Our Ref: F/31/17/PL
Your Ref:

Town & Country Planning Act 1990 (as amended)
Town and Country Planning (Development Management Procedure) (England) Order 2015
Application for Planning Permission

Development Extension to existing hard surfaced HGV parking area to accommodate 9 vehicles & 4 trailers
Location R T Page & Sons Ltd Unit R, Rudford Industrial Estate Ford

LOCATION PLAN - RUDFORD IND. ESTATE
 FORD ROAD, FORD, N. ARUNDEL, WEST SUSSEX.

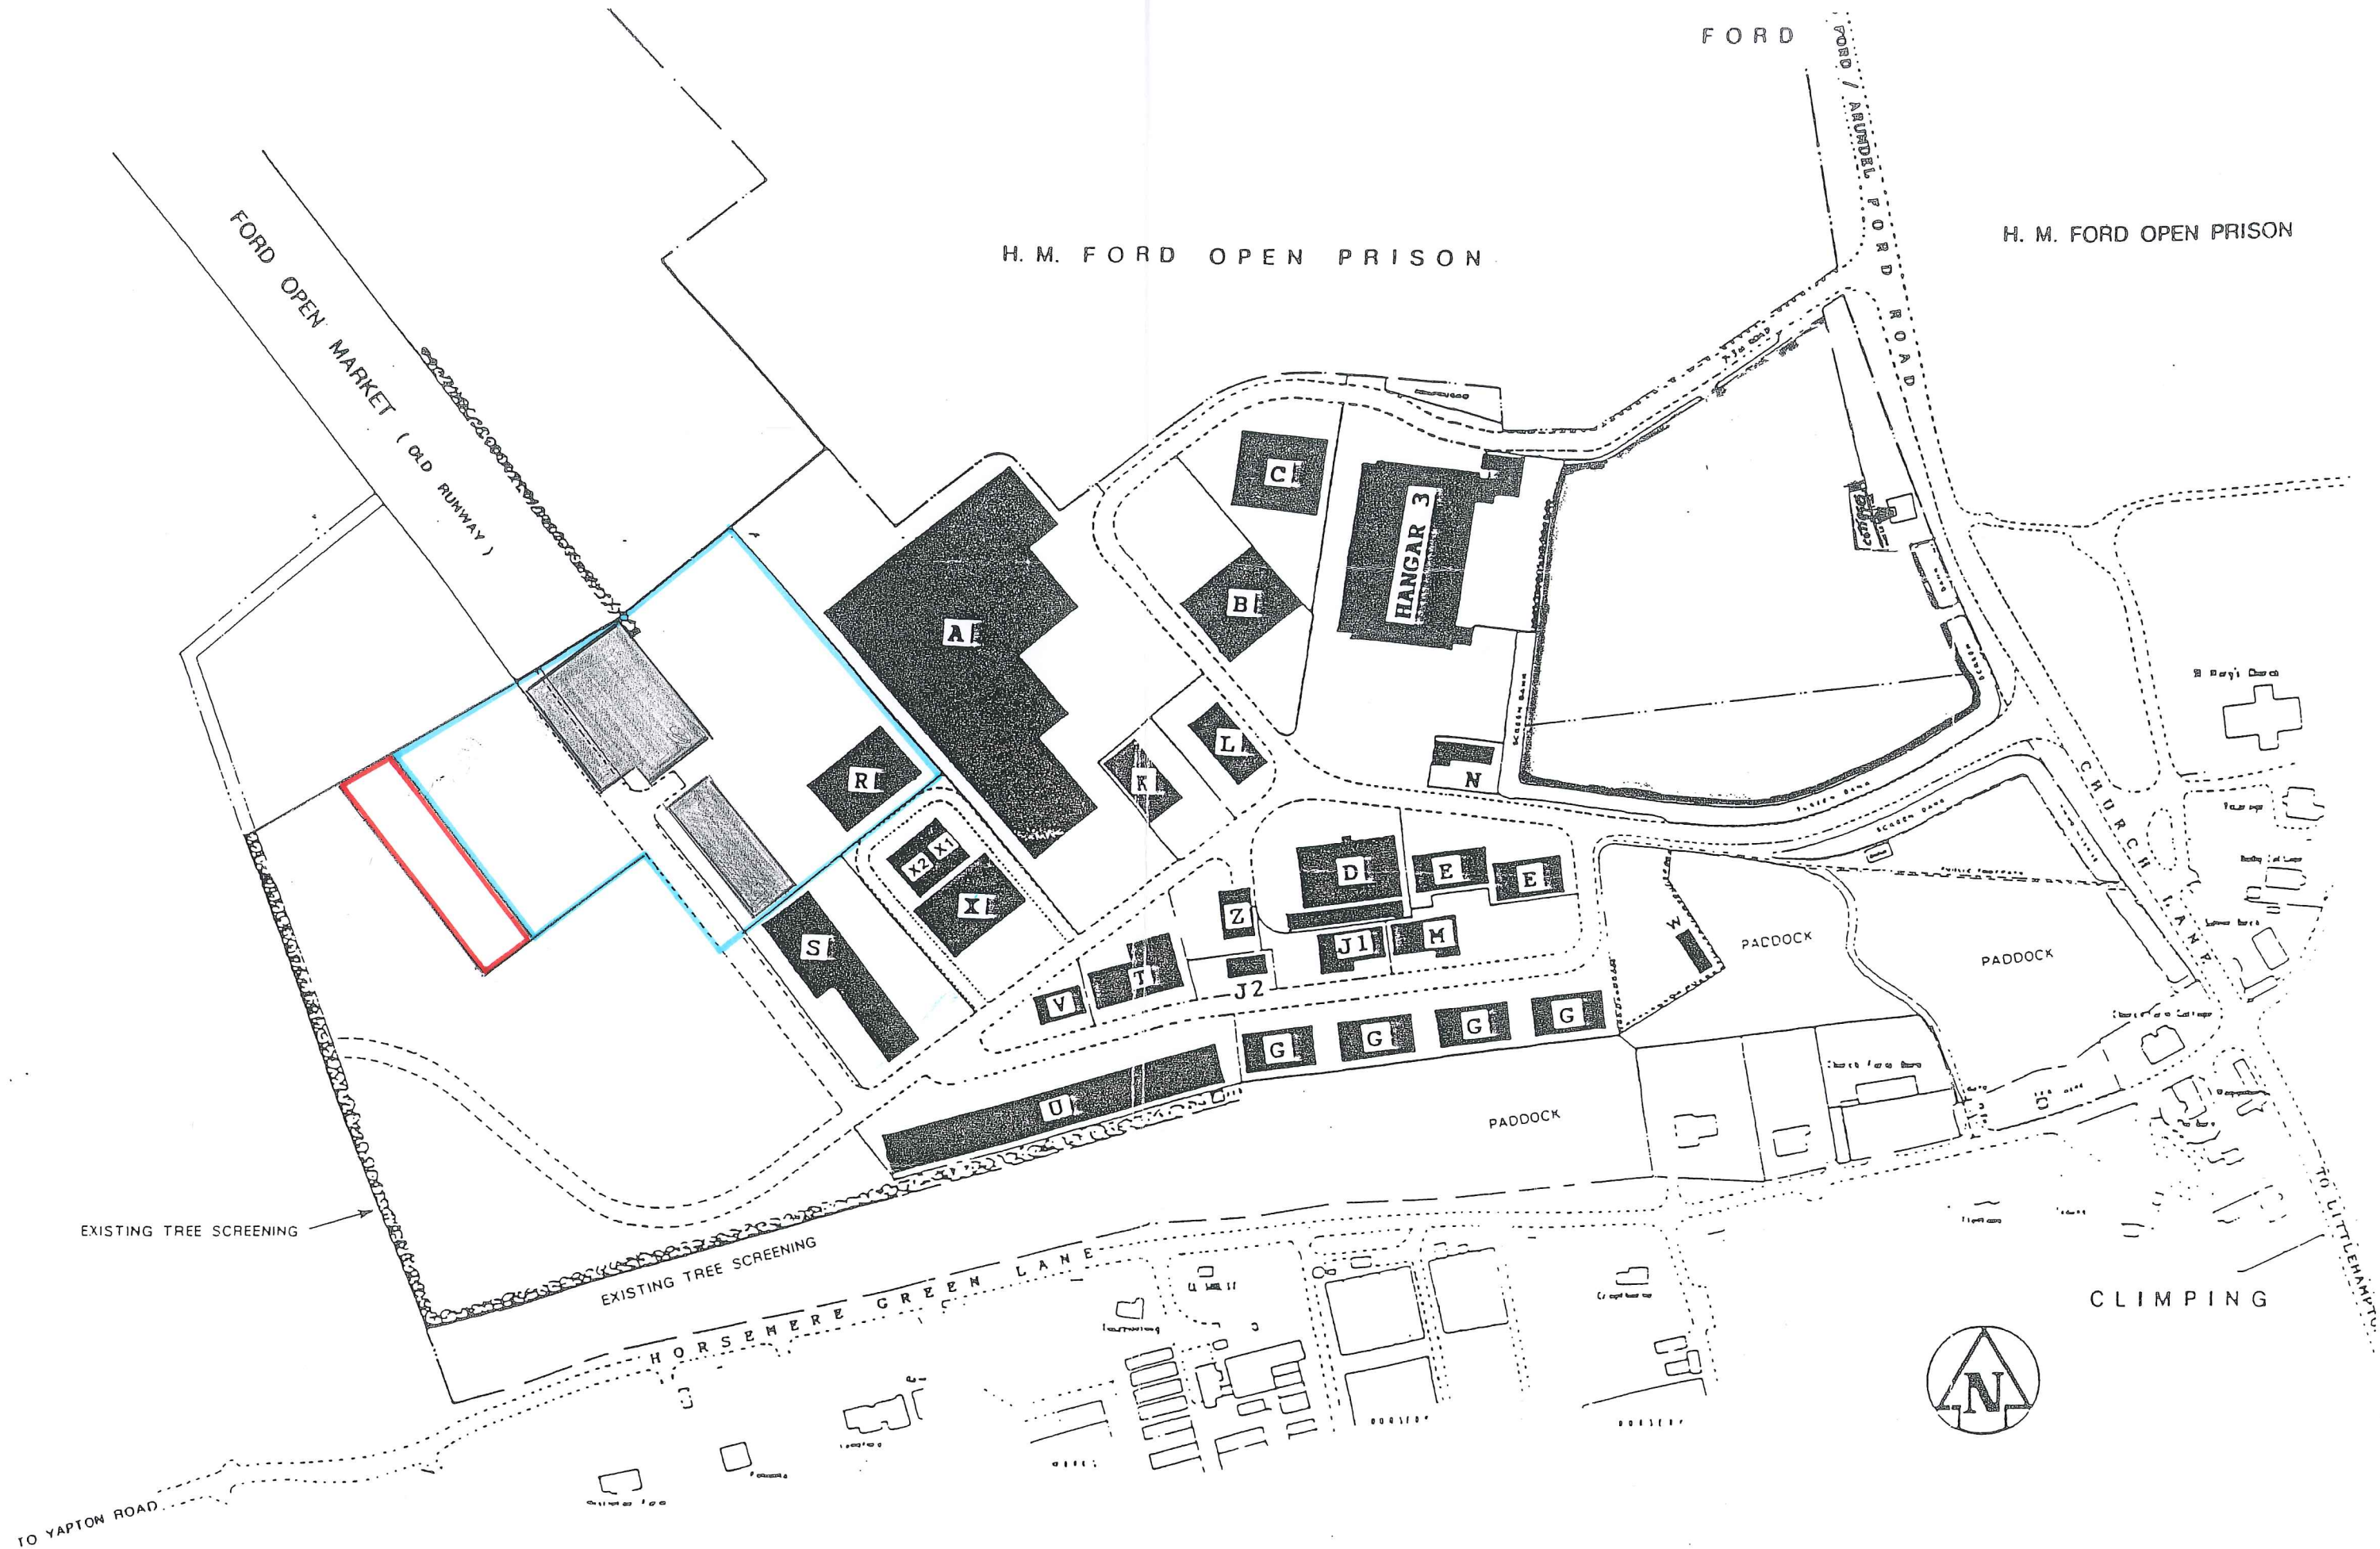
The location plan submitted is not to scale. Please submit 1 electronic or 3 paper copies of an amended location plan at a scale of 1:1250 or 1:2500 for rural areas. Further details of what must be included on the plan can be found in the National Validation Requirements.
